Subdivision Comments

From: Holly Erdman, Environmental Health Specialist II

RE: SP-23-00008 Rarden

RARDEN SHORT PLAT
 PREPARED FOR
 HALEY ANN RARDEN & JUSTIN TIMOTHY RARDEN
 A PORTION OF THE EAST HALF OF SECTION 20
 TOWNSHIP 20 NORTH, RANGE 14 EAST, W.M.

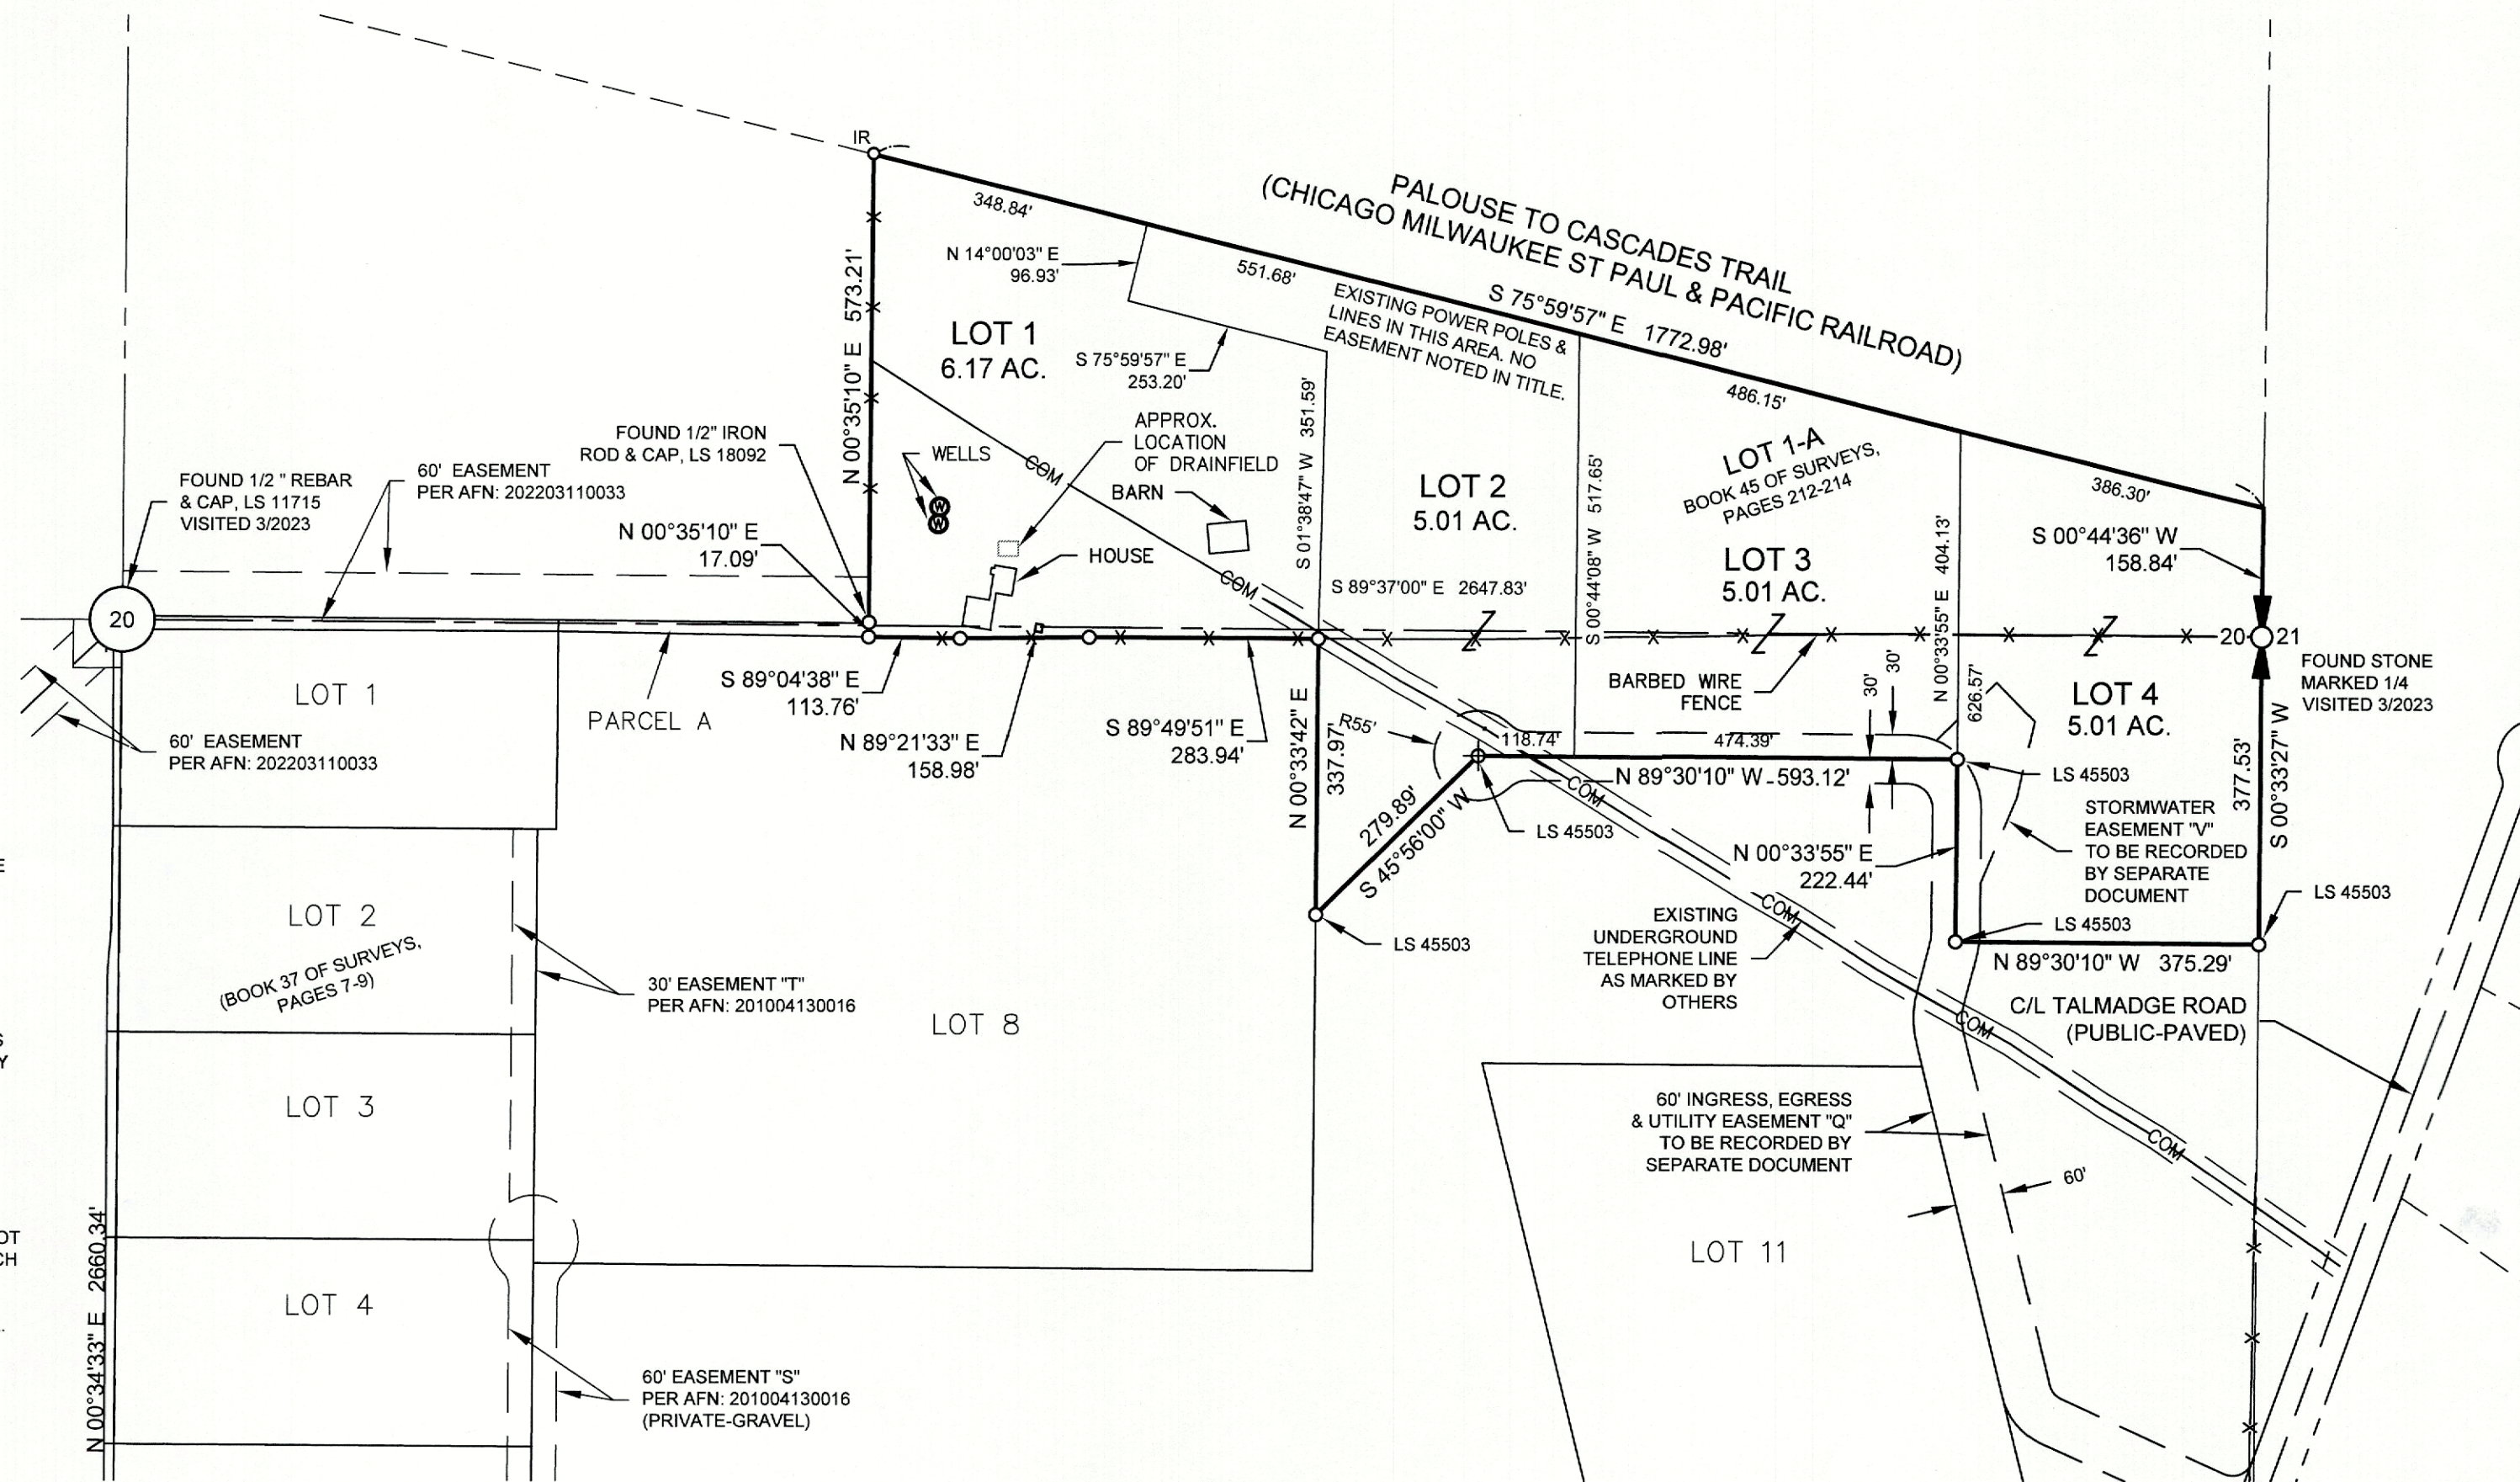
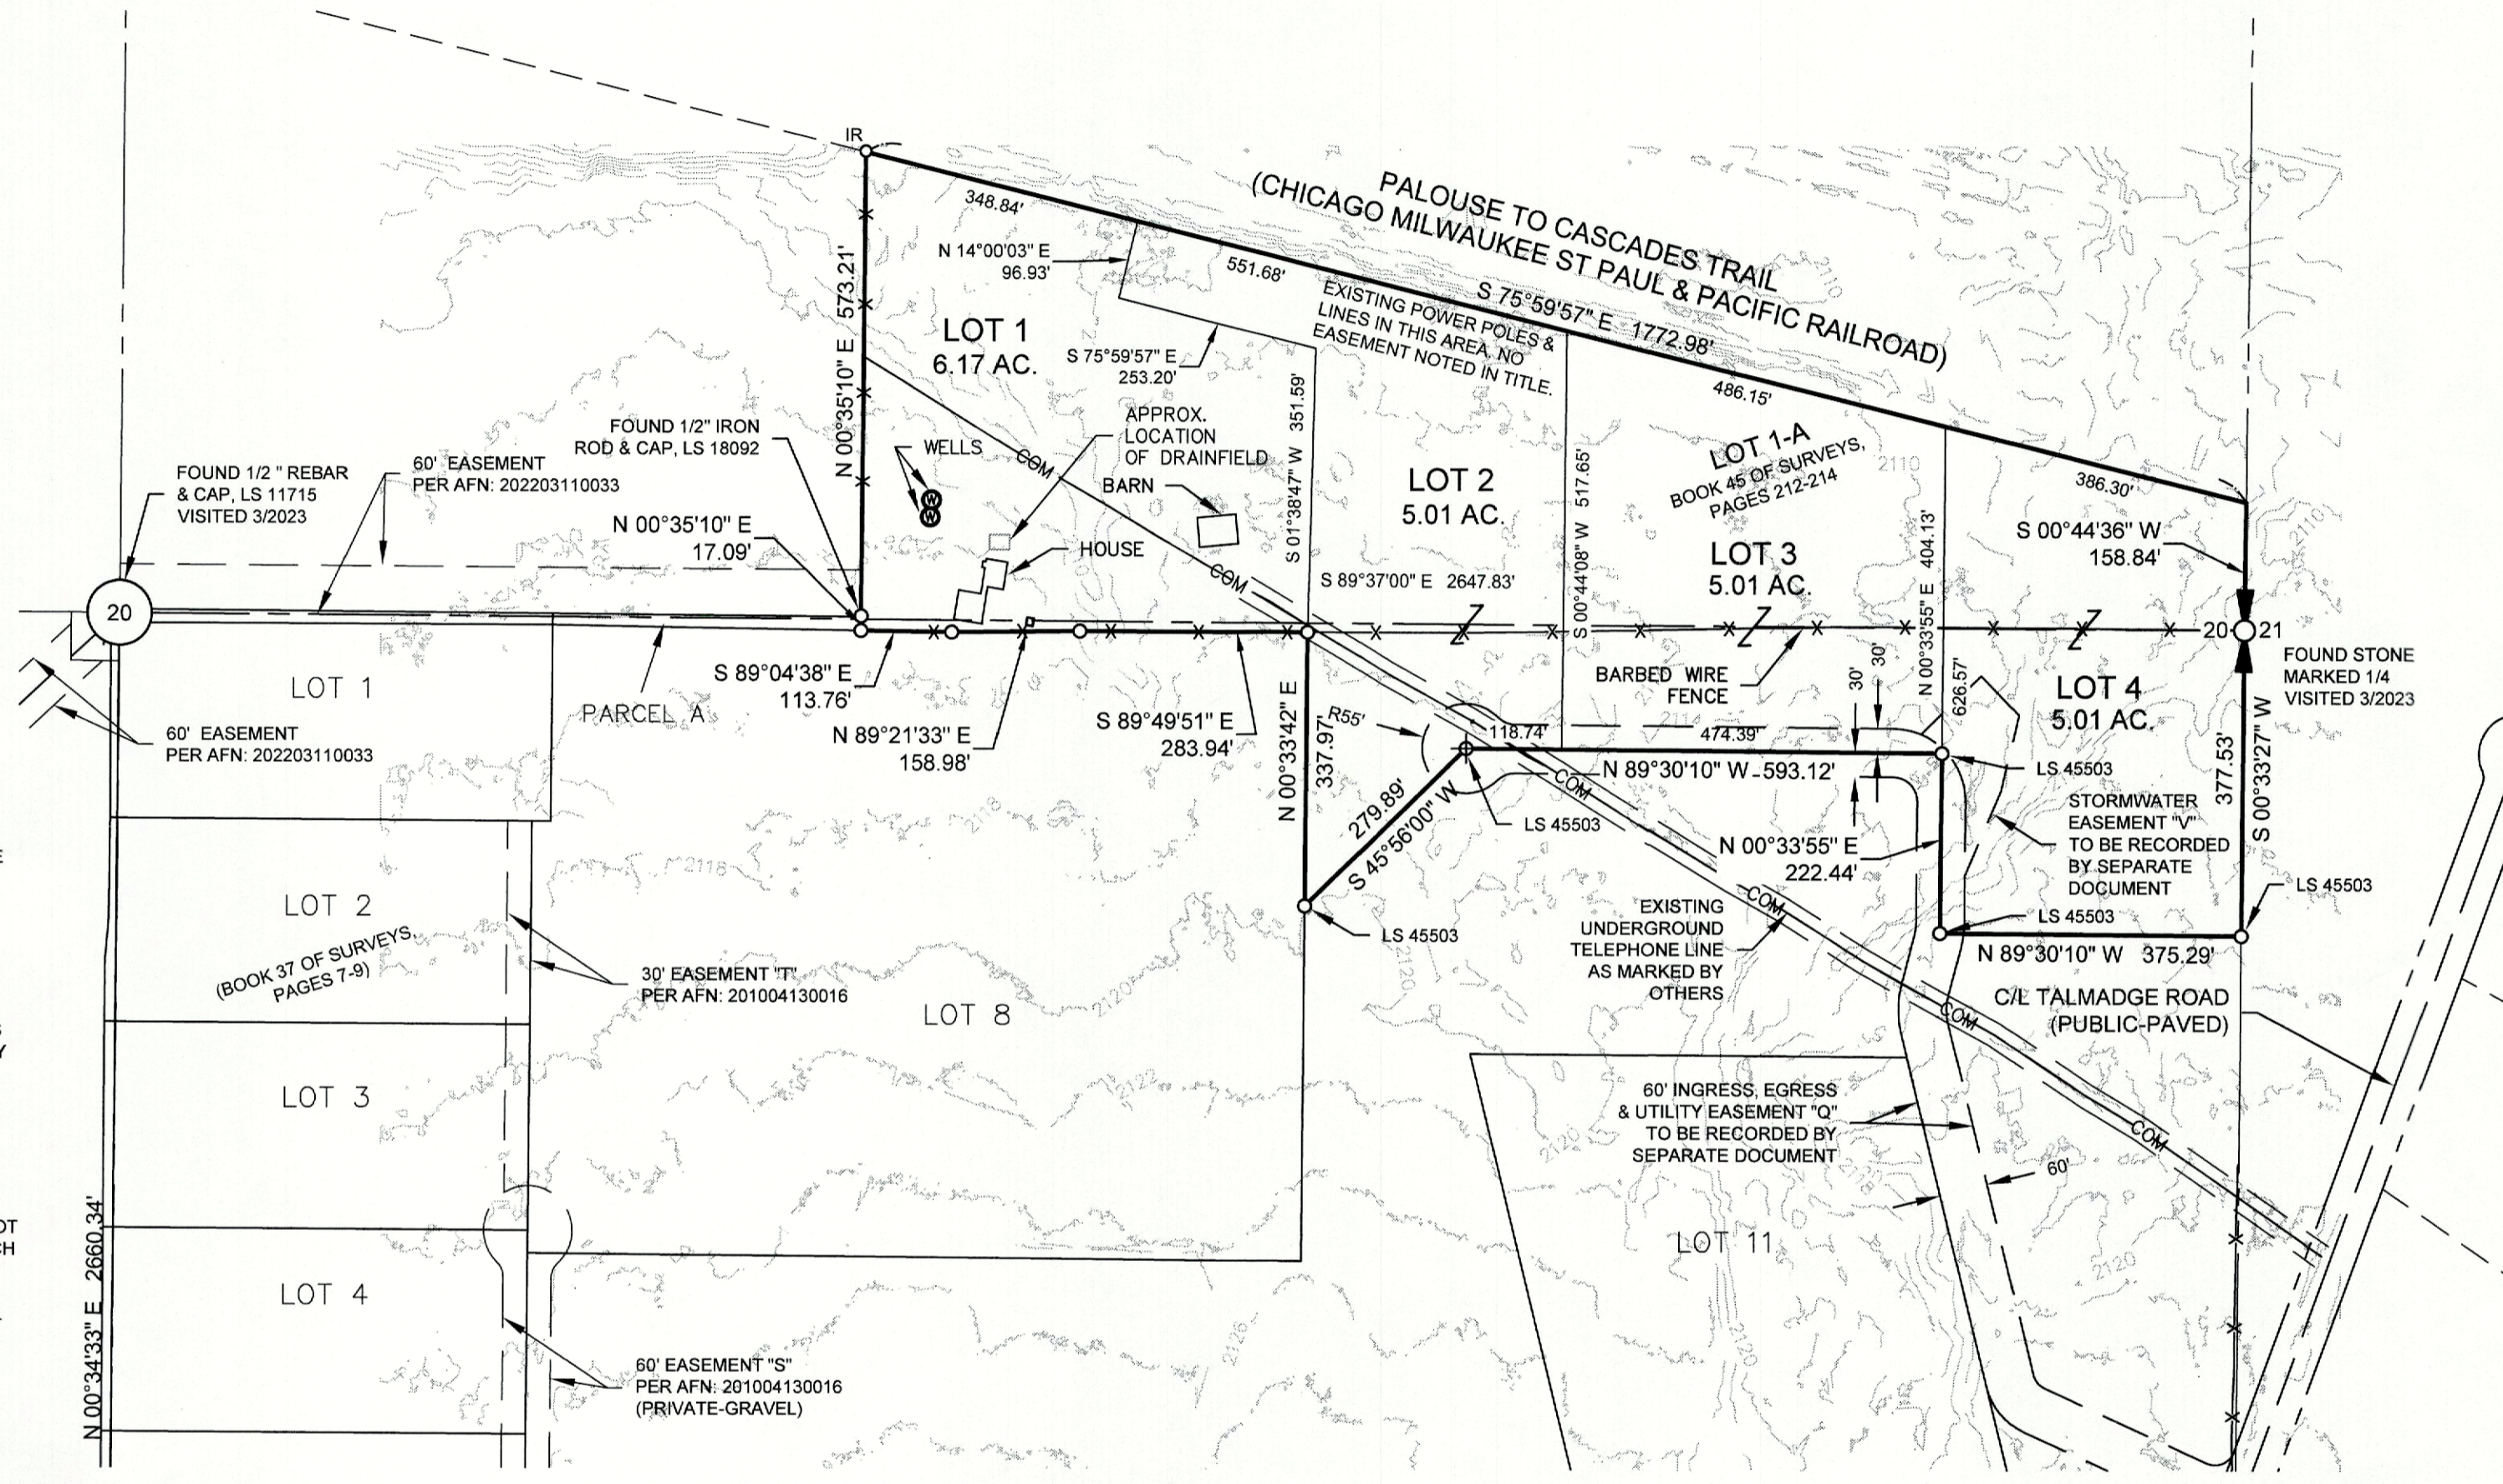
Well logs and water rights must be provided for the proposed lots. A well log is also needed for lot 1 but water rights are not required for that lot.
